PARKING LEVEL 1 -
ARCH 250

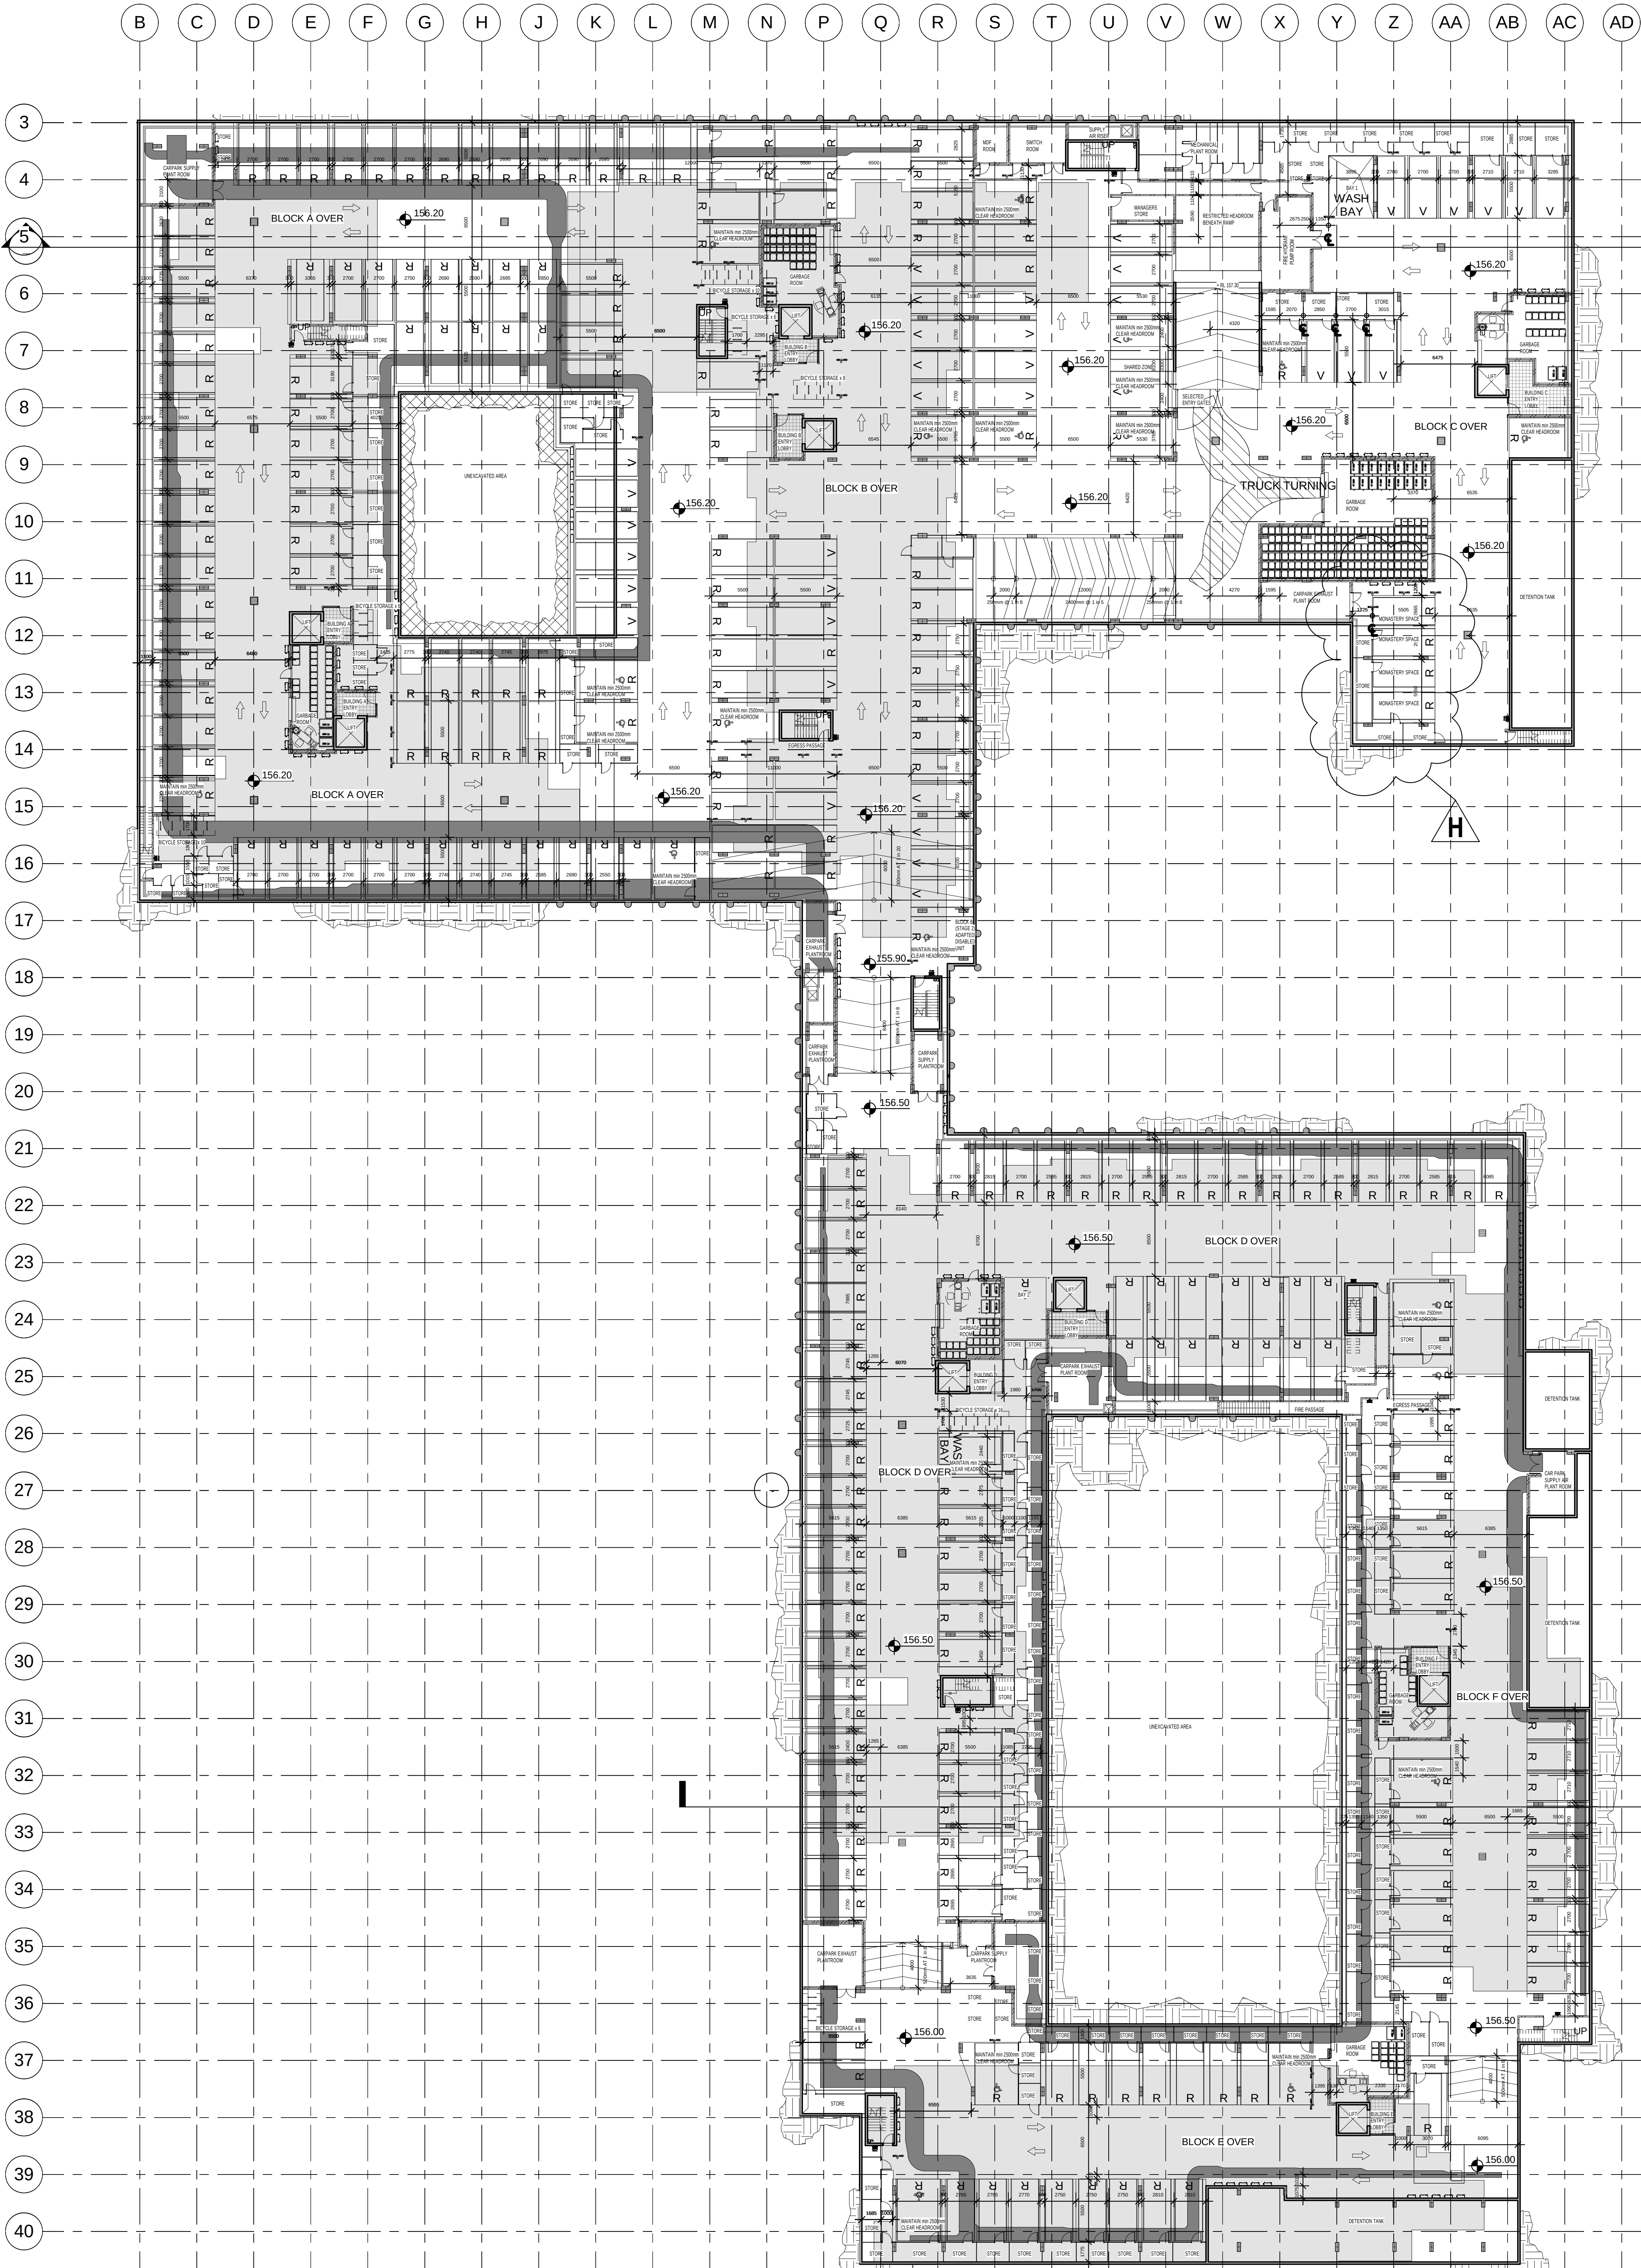
Carparking not satisfactorily addressed.

DRAWING TITLE:
MONASTERY - FLOOR PLANS

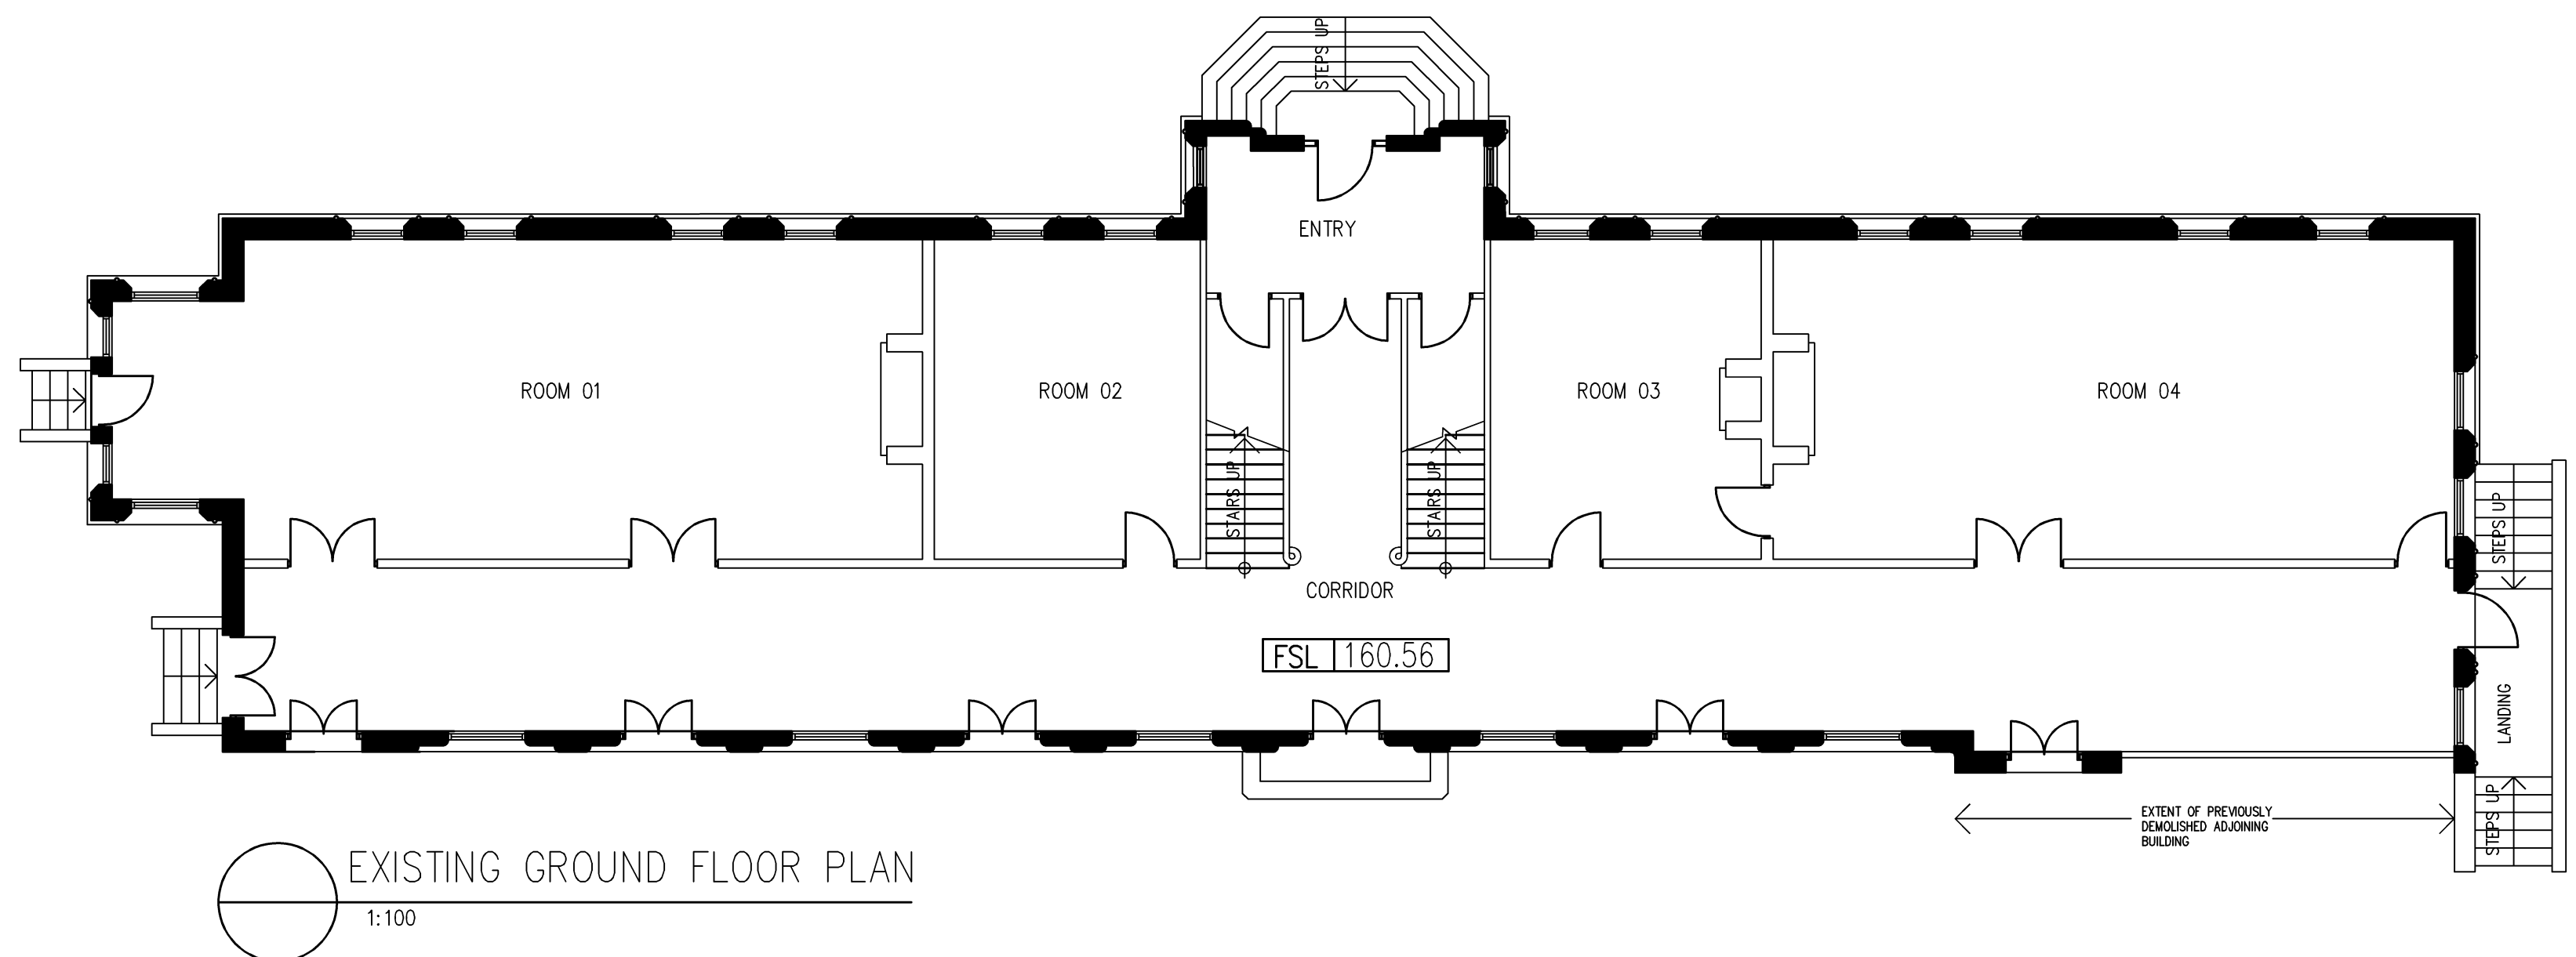
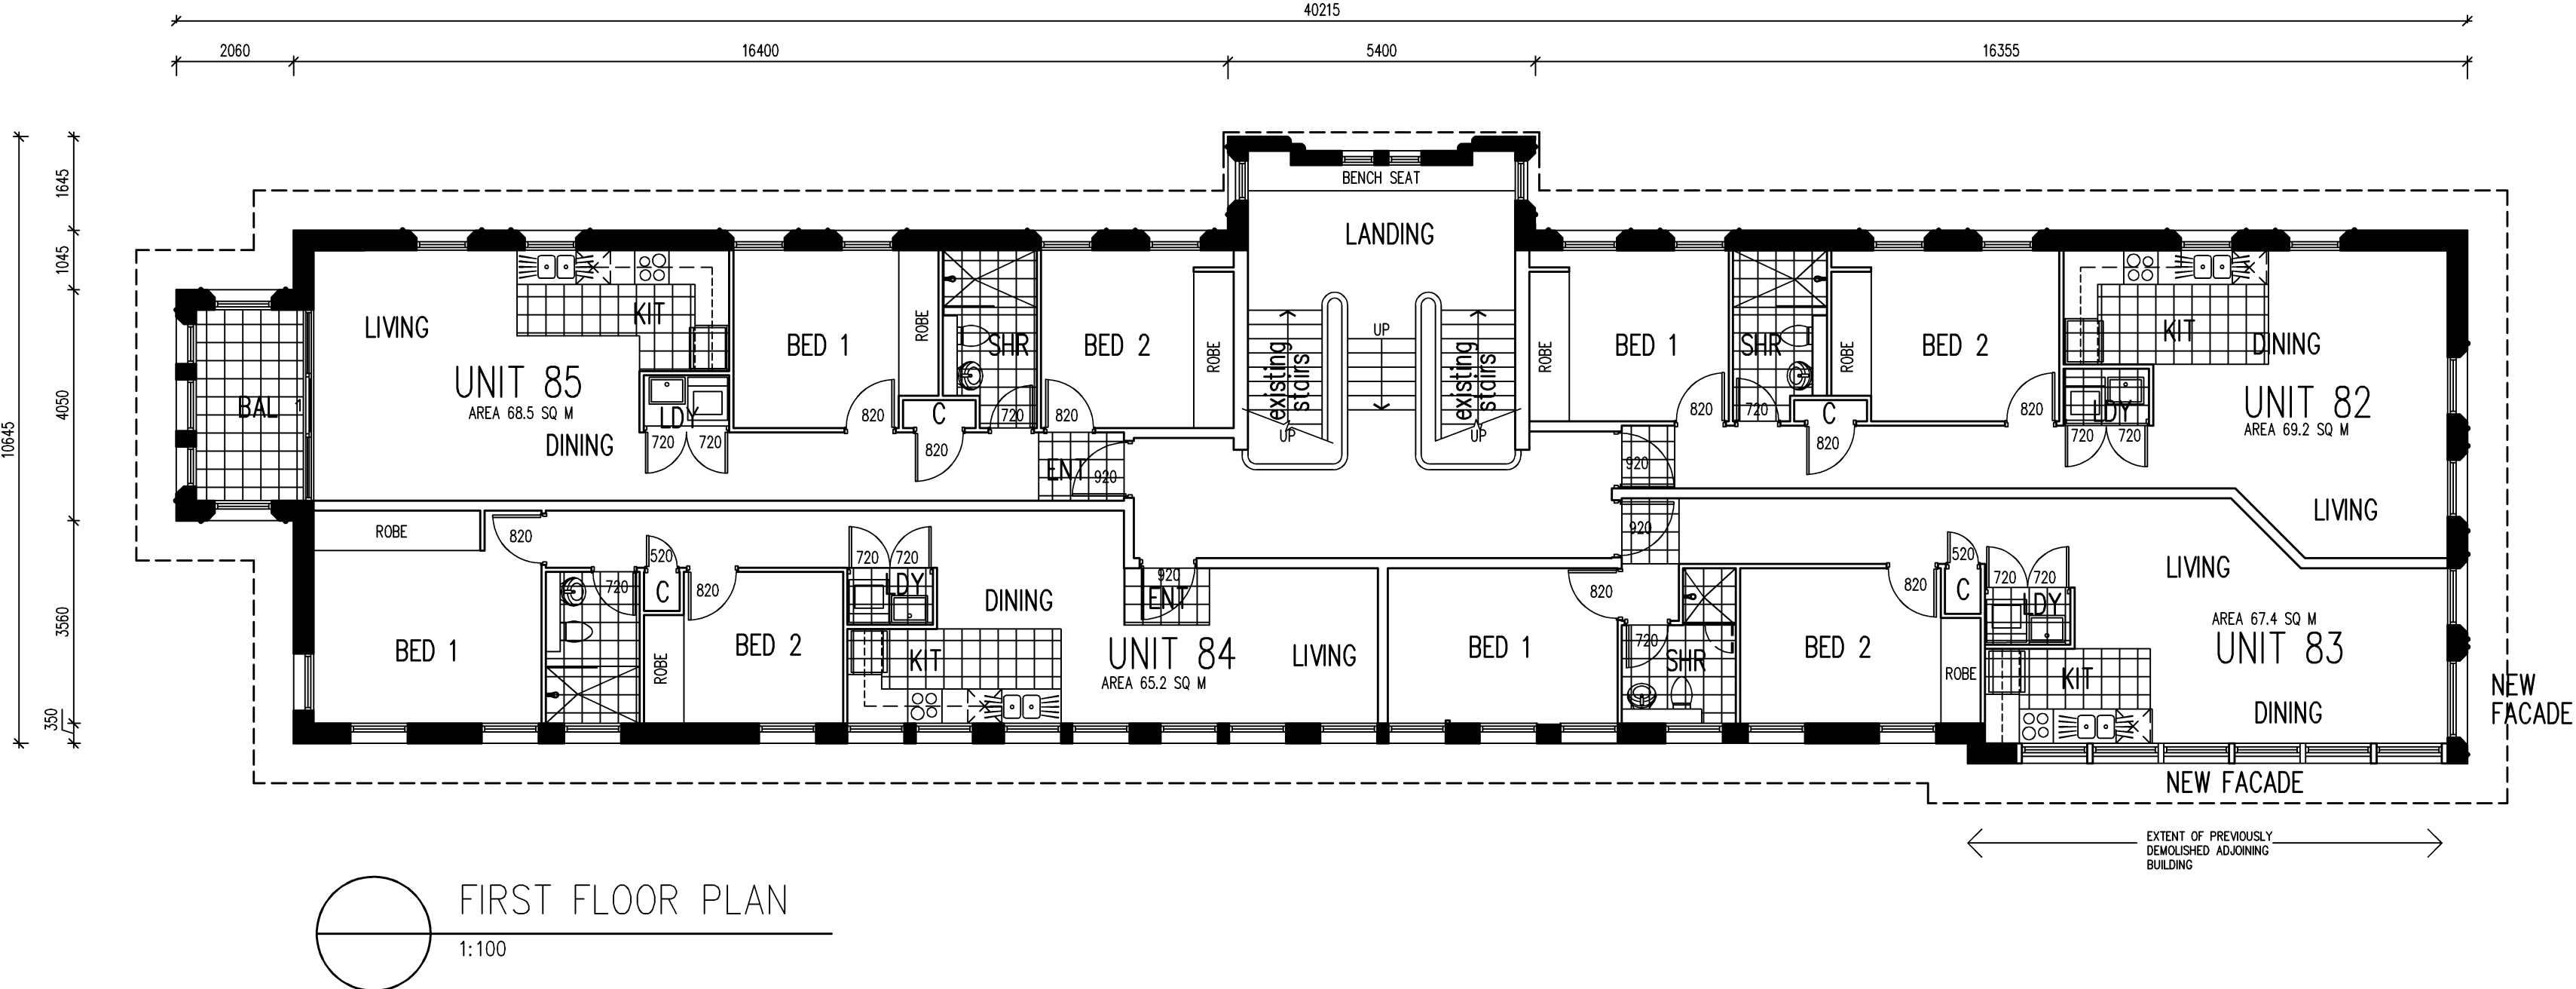
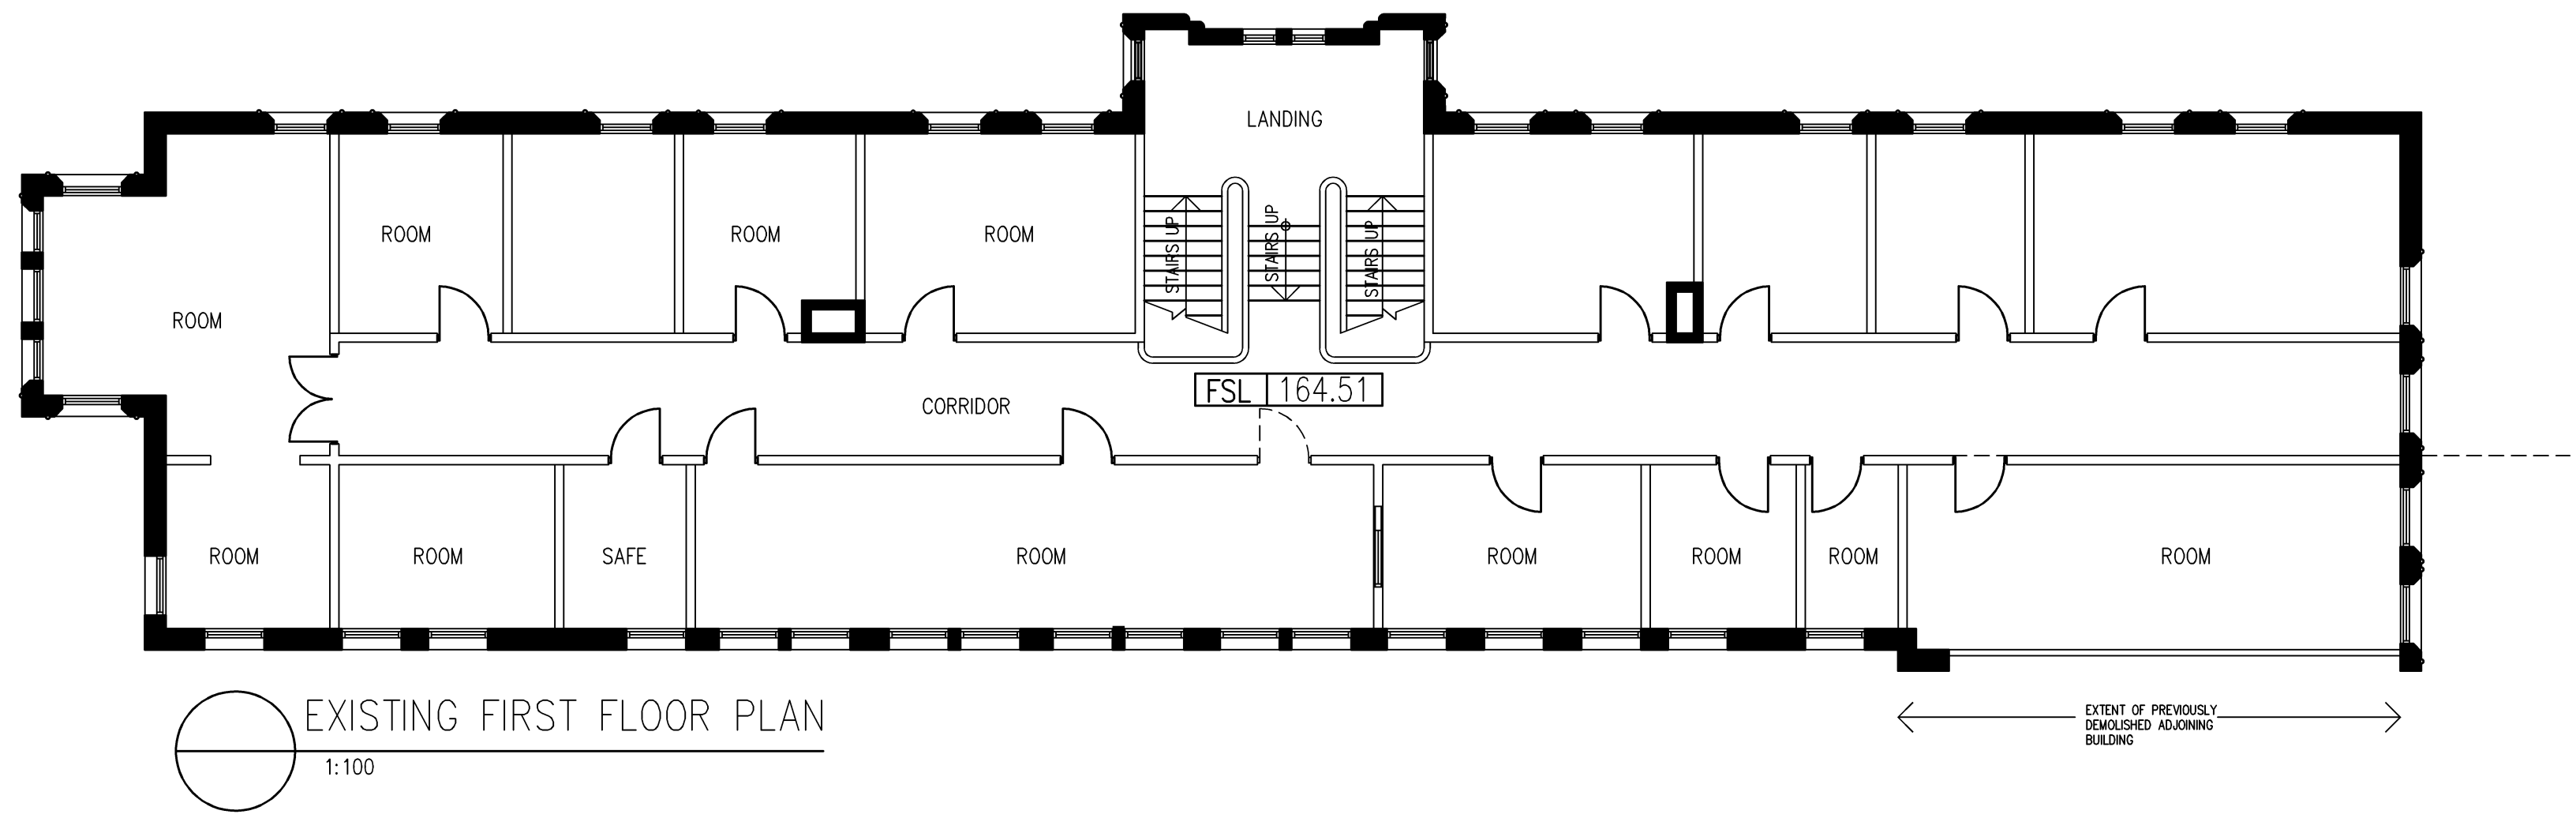
3 out of 4 proposed units fail to provide balcony/private open space for the respective units. This is unacceptable amenity for 2 bedroom units.

Unit sizes are not indicated on plan (to determine whether the units are in fact, undersized with the SEPP65/RFDC requirements).
